Appeal Decision

Appeal Ref: APP/A2525/A/04/1141623
4 Hillgate, Gedney Hill, Spalding, PE12 ONN

- The appeal is made under section 78 of the Town and Country Planning Act 1990 against a refusal to grant outline planning permission.
- The appeal is made by Mr and Mrs R. Hernon against the decision of South Holland District Council.
- The application (Ref:H07/1083/03), dated 1 September 2003, was refused by notice dated 23 December 2003.
- The development proposed is a single dwelling.

SITE LAYOUT
Scale 1:250

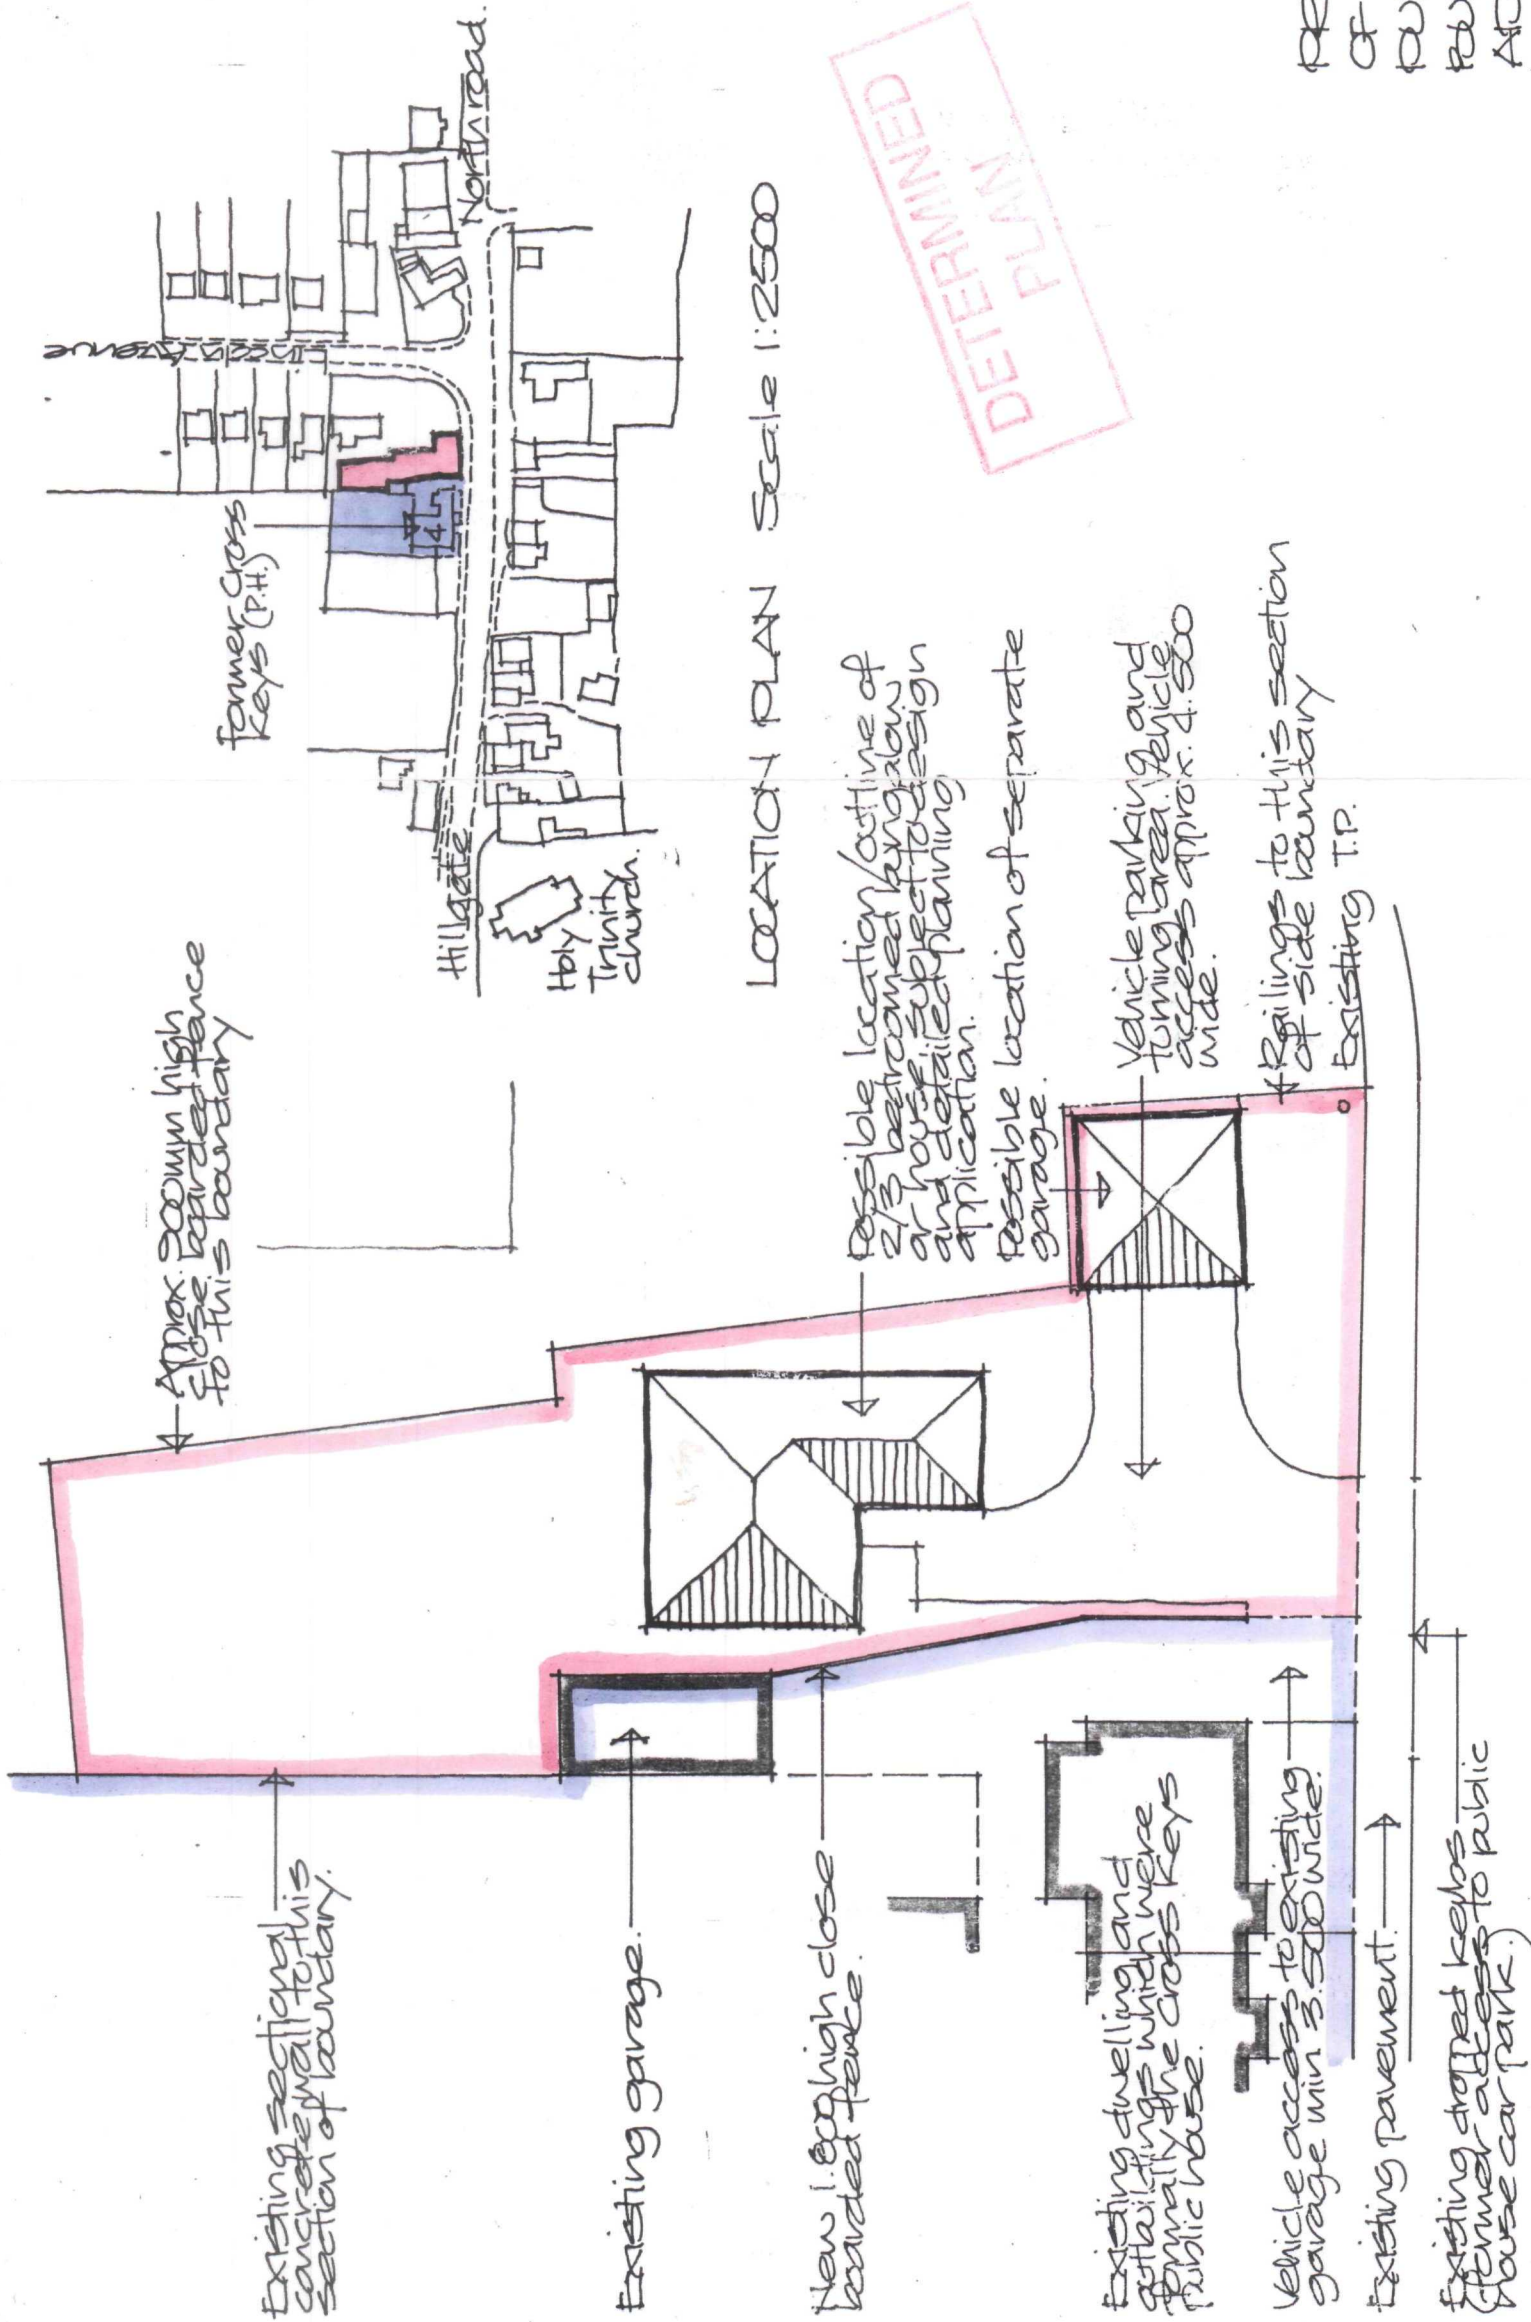
11. I turn now to consider the siting of the proposed garage which would be set forward of the proposed dwelling. This building would be sited some distance back from the front boundary and although set forward of the main dwelling it would be to the side, which to mind would significantly lessen the impact of the proposal on the streetscene. Furthermore, the garage would generally align with the front elevation of No. 4 and would therefore be compatible with the general pattern of development in this part of Hillgate.

20. I also note that the Parish Council have objected to the proposal as they consider that the proposed siting of the garage at the appeal site would obstruct the line of vision of neighbouring residents and traffic entering North Road. They also point out that there is a de-bussing stop for children opposite the appeal site and they consider that the proposal could cause a traffic hazard. Having observed the existing traffic conditions along the road and taking account of the achievable sight lines, the proposed access arrangement would be sufficient to ensure that drivers emerging from the access would adequately see or be seen by drivers proceeding along Hillgate. Furthermore, the proposed garage would be sited far enough back from the front boundary of the appeal site and far enough away from the junction of Hillgate, Lincoln Avenue and North Road so that it does not unacceptably obstruct the line of vision of neighbouring residents or drivers using the local road network.

- 2 In the opinion of the Local Planning Authority the siting of a detached garage in a prominent position forward of the dwelling would result in an incongruous form of development harmful to the existing street scene. The proposal would therefore be contrary to Policy E1 of the South

12. I therefore conclude that a single storey dwelling with a detached garage would be in scale and character with its surroundings and would be in keeping with the general character of the village. As a result, the proposal would comply with the objectives of Structure Plan Policy 5A and Local Plan Policies H2 and E1. Furthermore, as the proposal would front onto the existing highway and would be self contained within the village framework the proposed dwelling would also comply with the objectives of Policy H2A of the Interim Rural Housing Planning Statement.

- 5) No building on any part of the development hereby permitted shall exceed one storey in height.
- 6) No development shall take place until there has been submitted to and approved in writing by the local planning authority a plan indicating the positions, design, materials and type of boundary treatment to be erected. The boundary treatment shall be completed before the dwelling is occupied. Development shall be carried out in accordance with the approved details.
